**Application by Highways England for the A1 in Northumberland: Morpeth to Ellingham  
The Examining Authority's written questions and requests for information (ExQ2)  
Issued on 19 March 2021.**

**Responses are due by Deadline 5: 1 April 2021.**

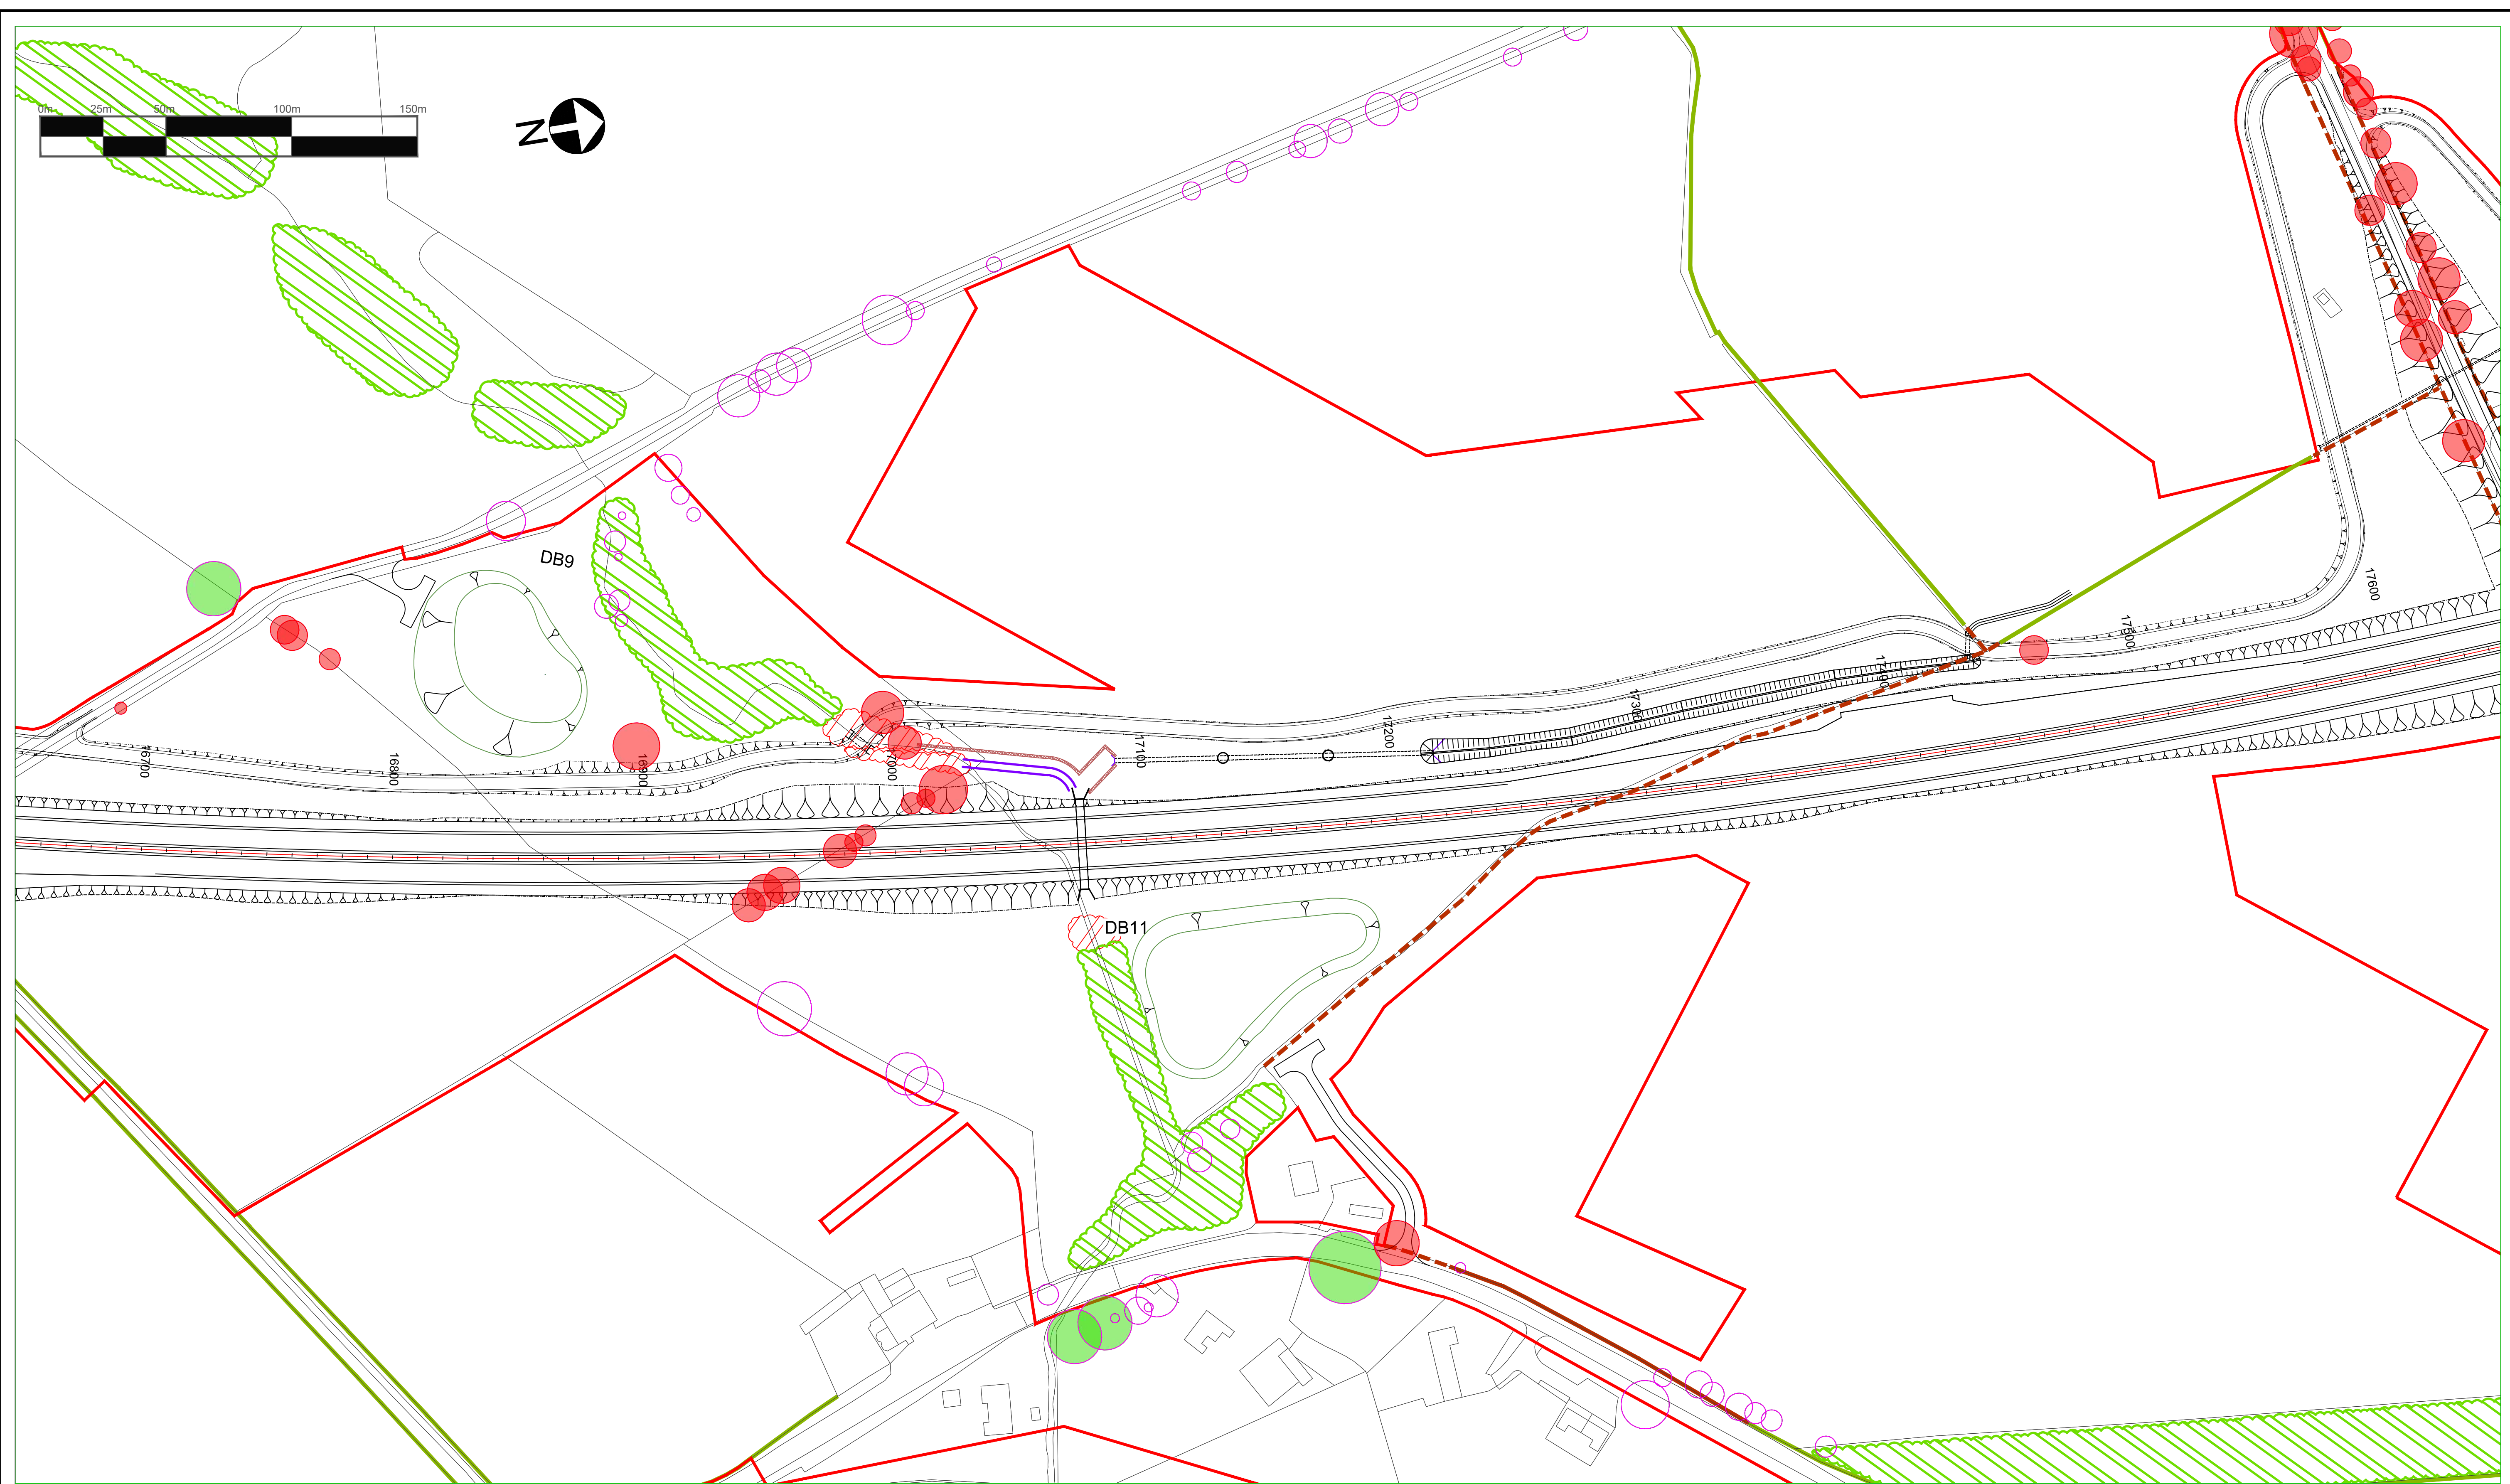
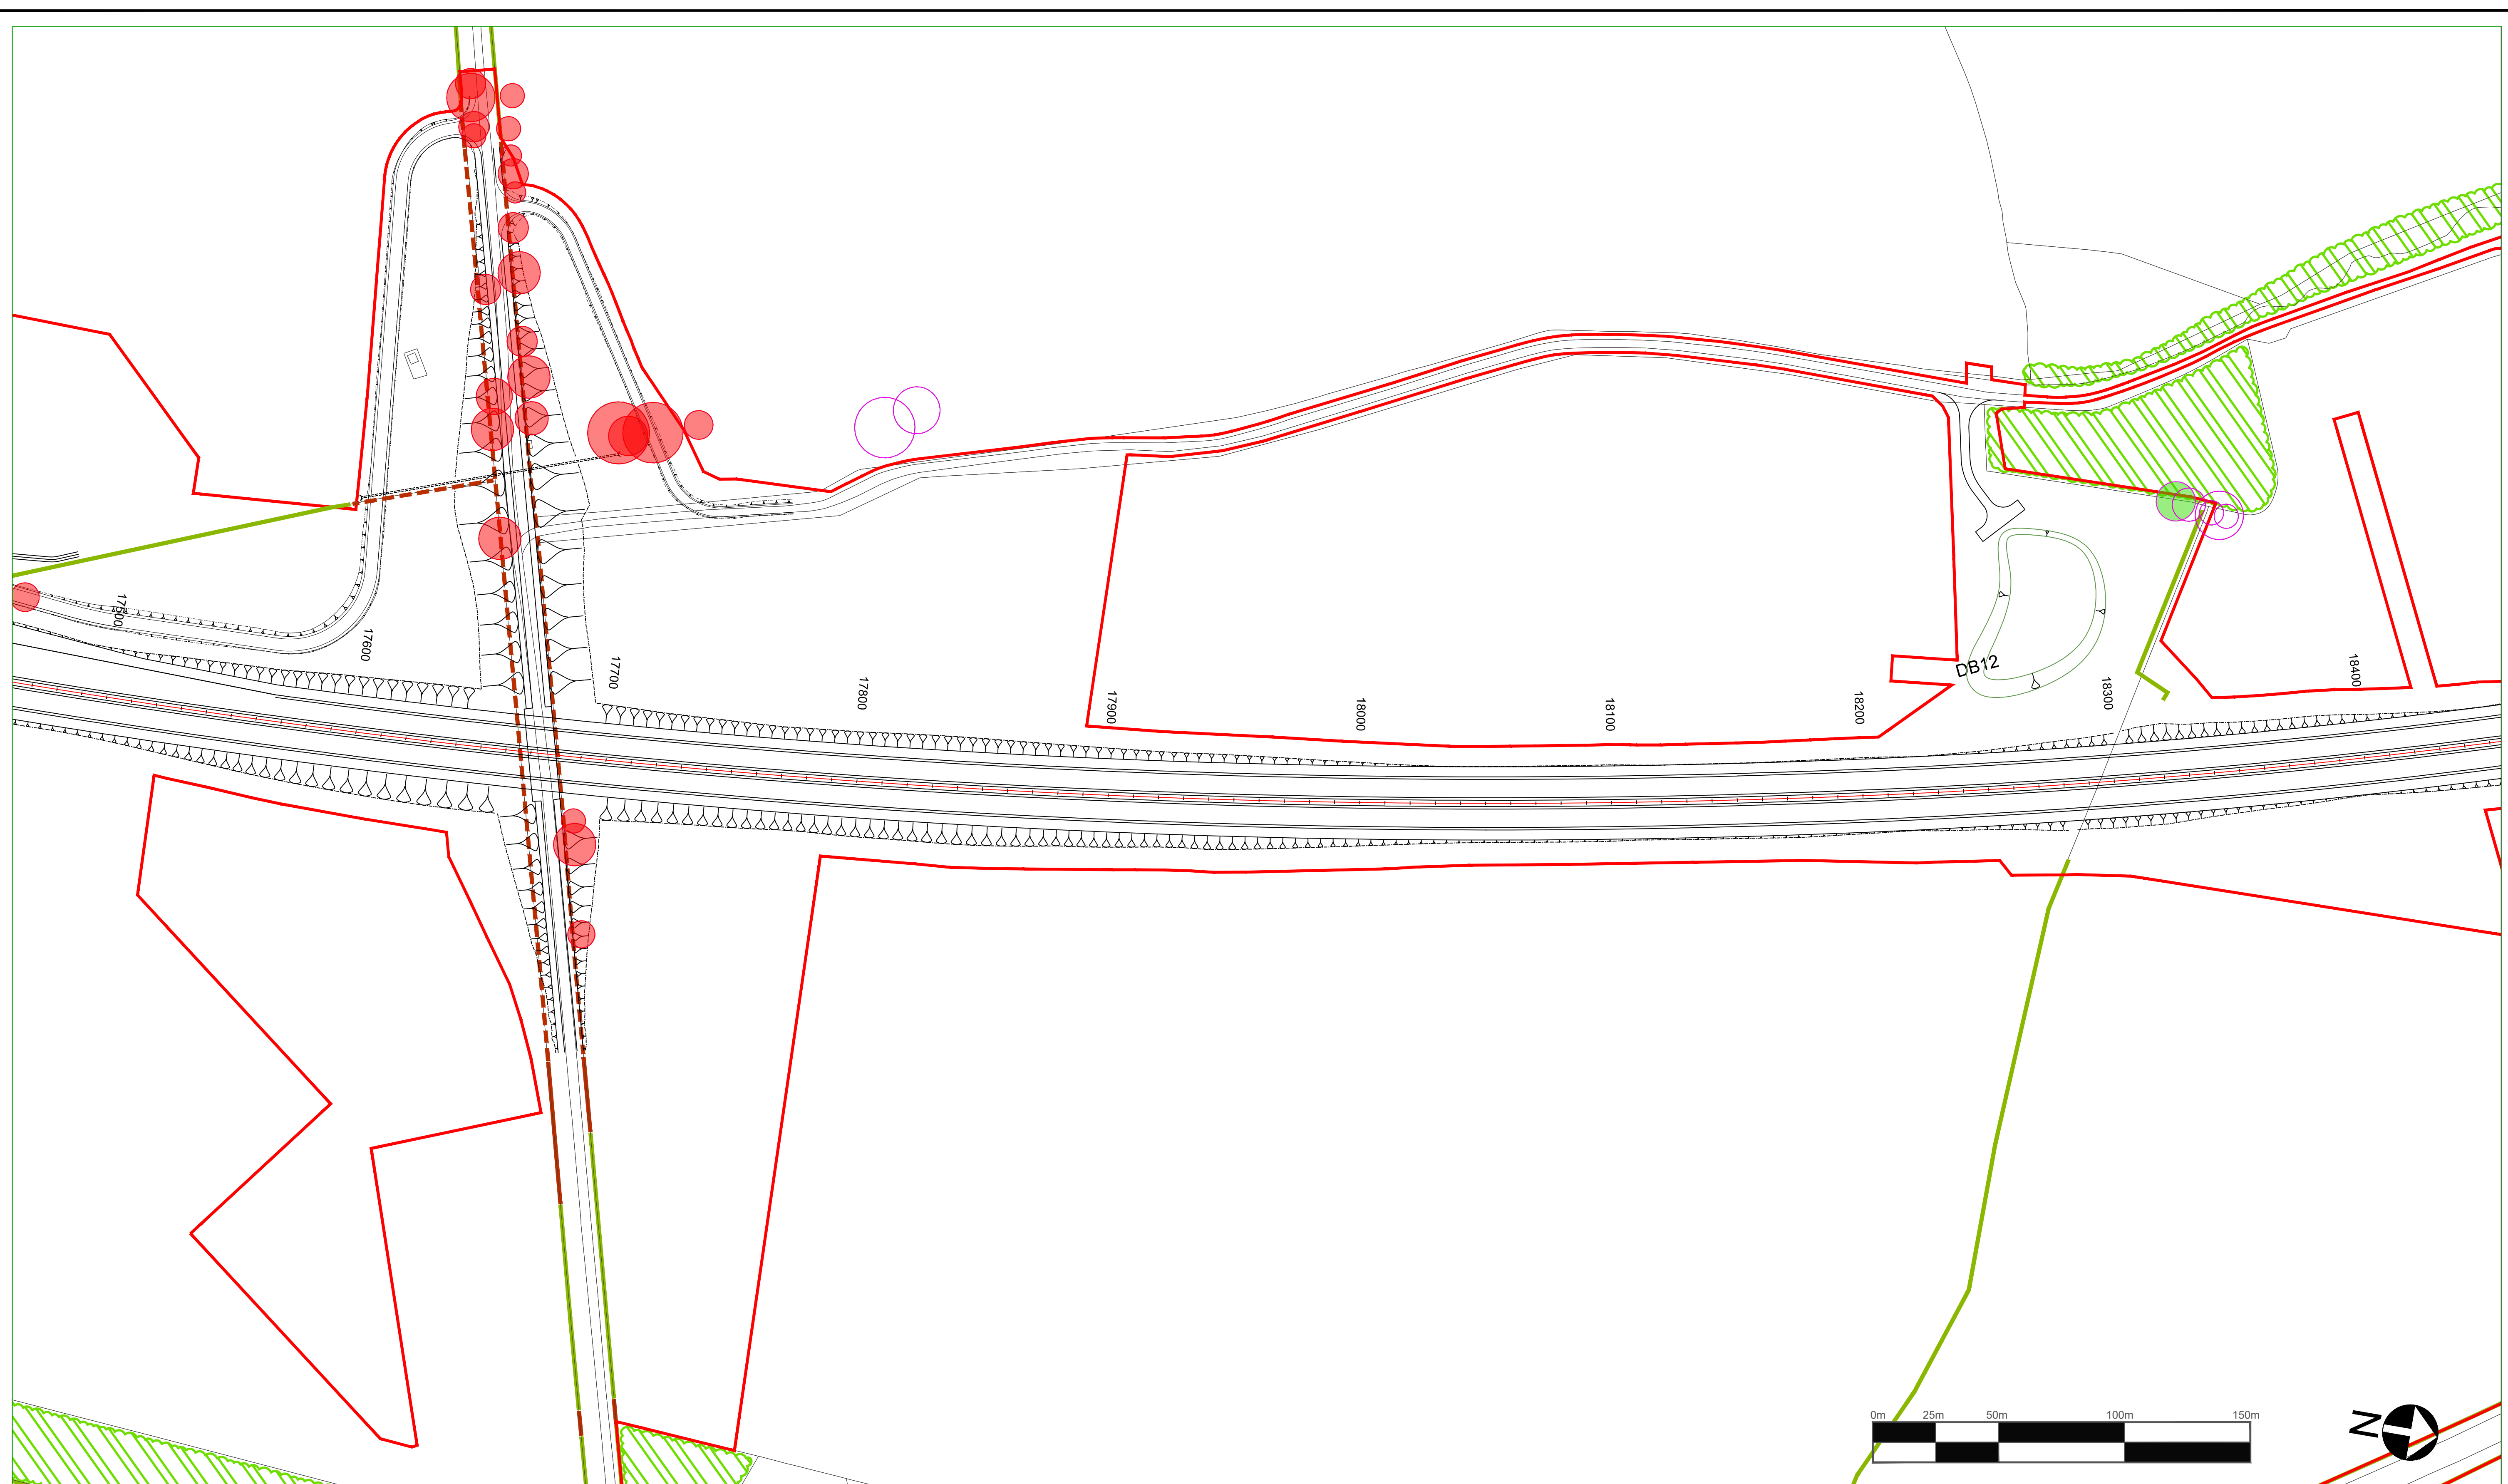
<b>ExQ1</b>	<b>Question to:</b>	<b>Question:</b>
		<b>PART B</b>
LV.2.21	Applicant	Vegetation Clearance Plans [REP4-003] show the existing vegetation to be retained, the existing vegetation to be removed and also the results of the Arboricultural Survey. Can the Applicant confirm the intentions for vegetation removal in front of West Linkhall Farm and West Lodge at Charlton Hall? How would this be secured through the DCO?
<b>MATERIAL RESOURCES</b>		
MR.2.1	Applicant	The Applicant's Comments on the LIR [REP3-025] responding to paragraph 6.10.2 of the LIR indicate that all practicable efforts will be made to achieve sustainable resource management and that information on achievements in this context will, where appropriate, be made available to NCC during detailed design. What is the mechanism by which this information will be provided?
MR.2.2	NCC	The Applicant's Comments on the LIR [REP3-025] responding to paragraph 6.10.3 of the LIR address discrepancies raised by NCC in the potential capacity for inert landfill in the county as set out in Table 13-11 of the ES [APP-056] [APP-057]. Is NCC content with the Applicant's response?
